Your Ref
BE/22/18/DOC
Our Ref
PLAN-023737
Date
27/07/2018

Proposal: Approval of matters reserved by condition imposed under BE/18/17/PL relating to conditions 4-archaeological works, 5-surface water drainage, 9- landscape scheme, 10-protection of existing trees/bushes/shrubs, 14-foul drainage, 15-ecological enhancement scheme, 17-landscape management plan, 18-details of laying out timetable for provisions & future maintenance of Public Open spaces, 20-10% decentralised & renewable or low carbon energy sources, 21-street lighting scheme, 23-vehicle access, 25-car parking spaces, 27-construction of road(s), footways & casual parking areas & 28- Travel Plan statement.
Site: Land West of New Barn Lane, Bersted, PO21 5DL.
BE/22/18/DOC

Project Name	North Bersted
Client	North Bersted
Drawn by	ANV
Checked by	ANV
Scale	1:250 @ A0
Sheet No.	17
Project No.	145323-1002
Rev	C

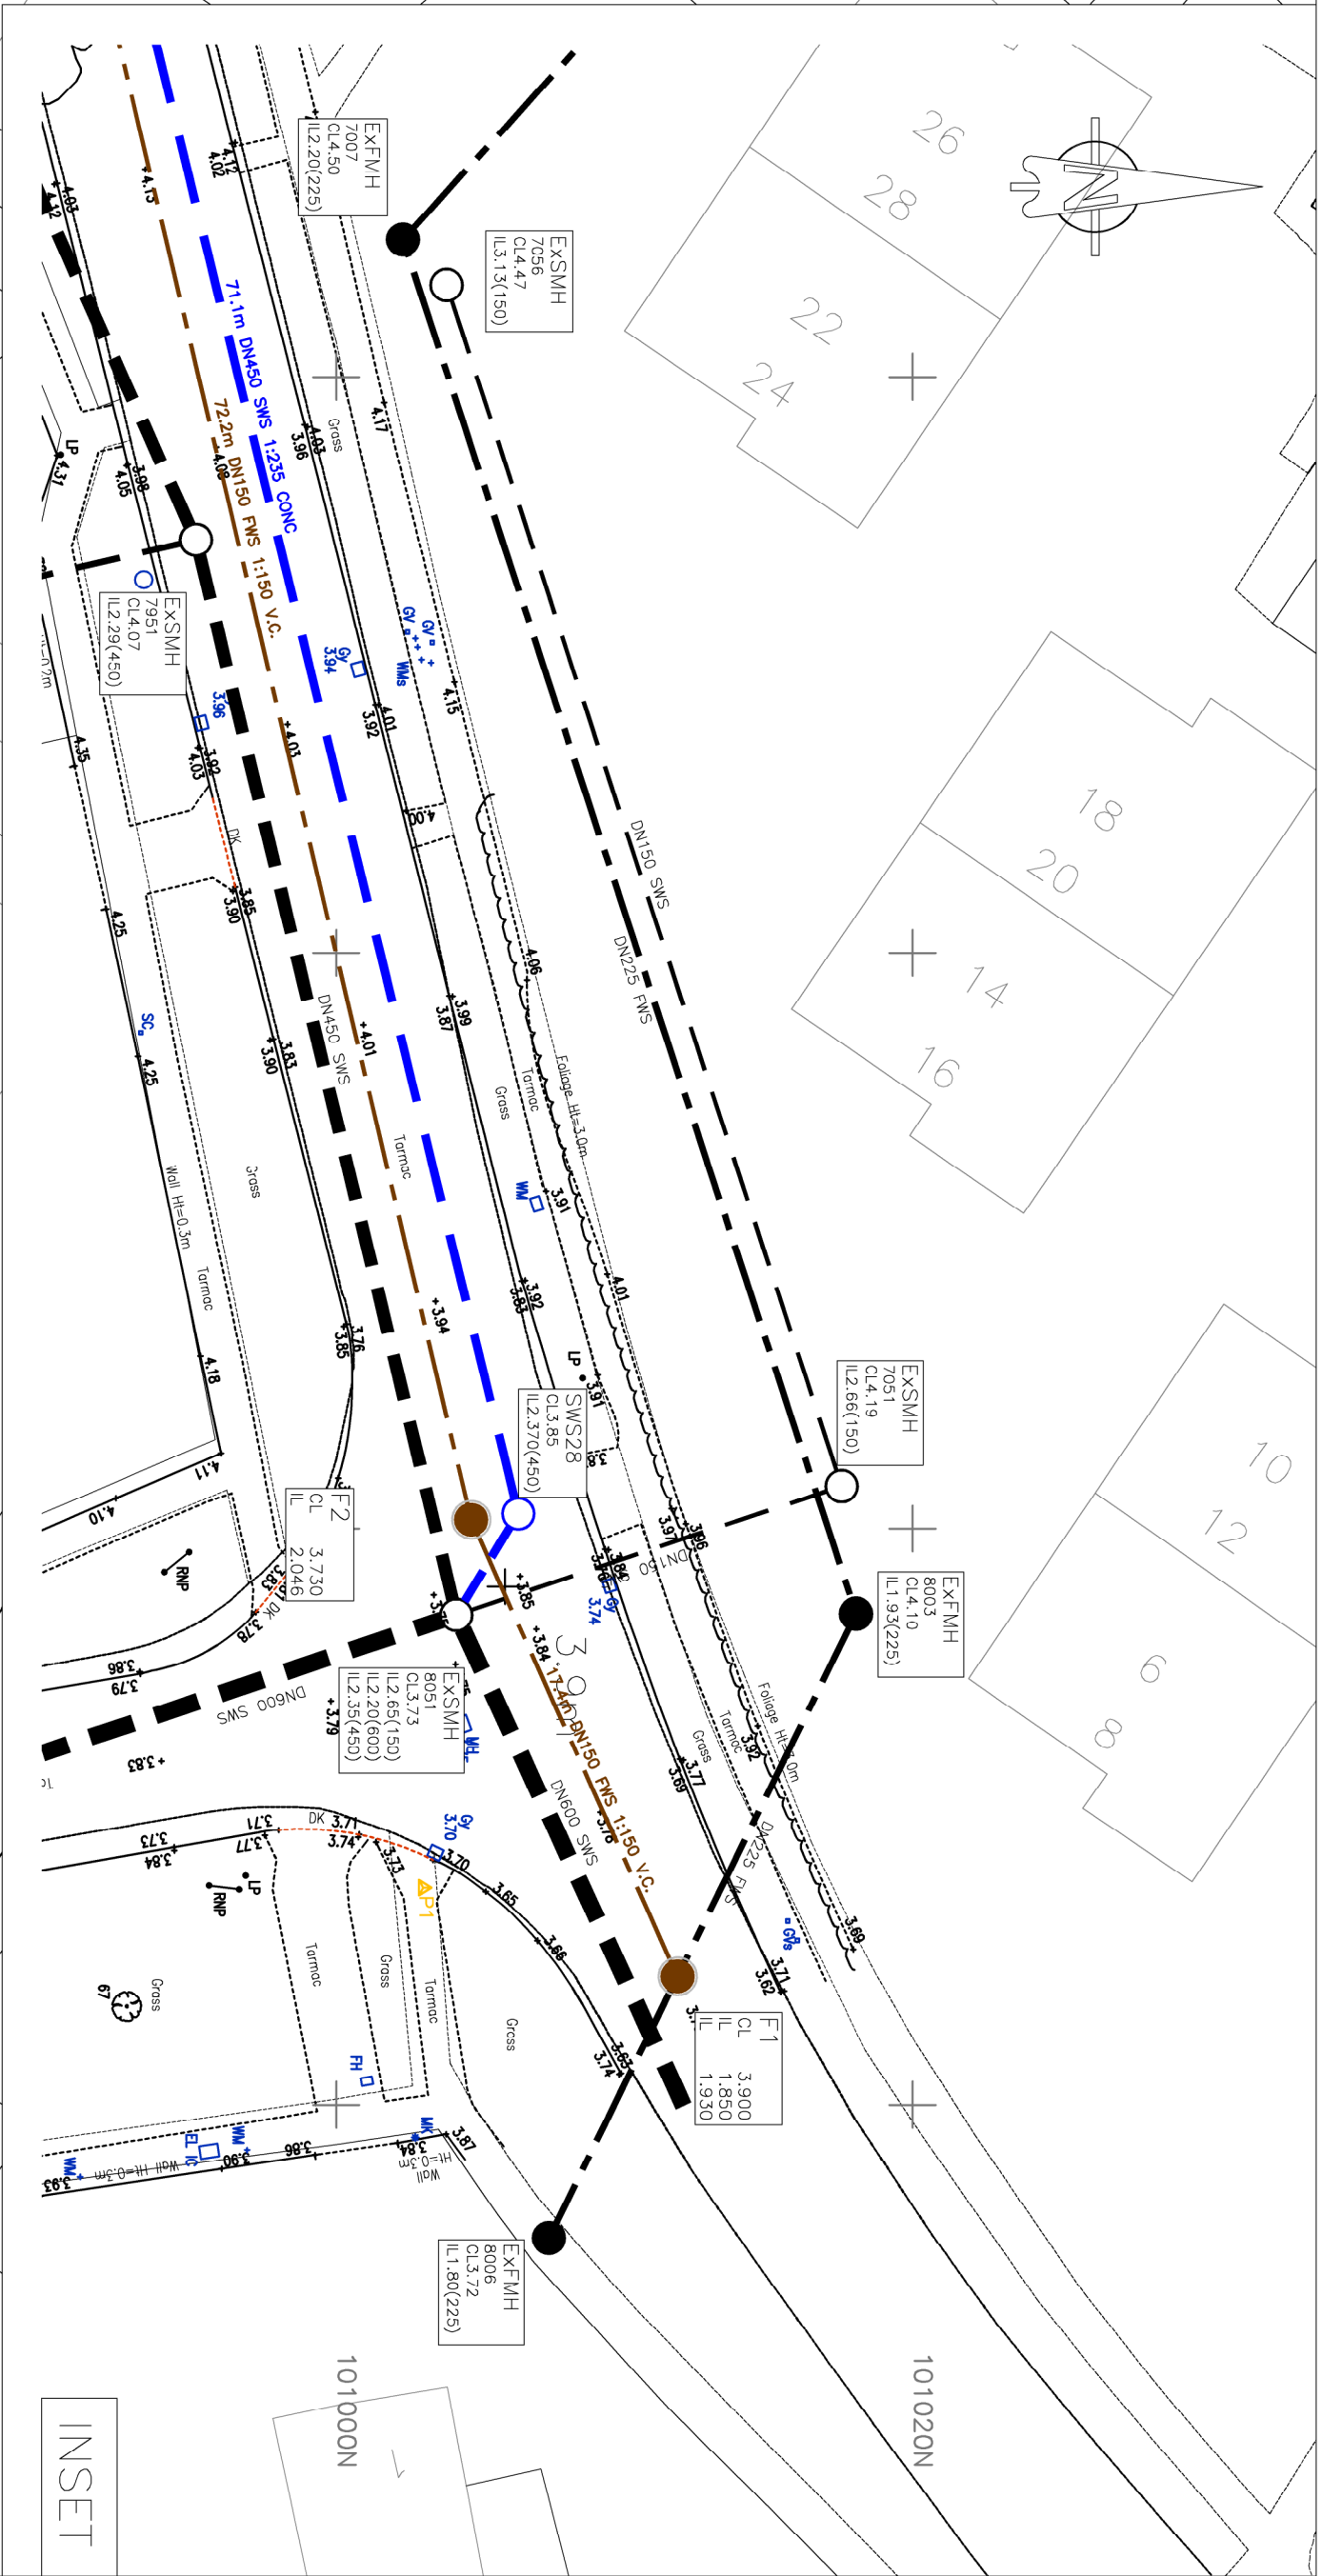
The proposed drainage strategy shows overflows from a pond discharging into surface water system which is not acceptable to Southern Water. The design of drainage should ensure that no overland or groundwater is to enter the public sewers to prevent risk of flooding of downstream properties.

The proposed drainage plan also shows a diversion of the public sewer. Please note, that Southern Water will not accept any diversion of the public sewers until an application under Section 185 of the Water industry Act 1991 is submitted and agreed before implementing onsite.
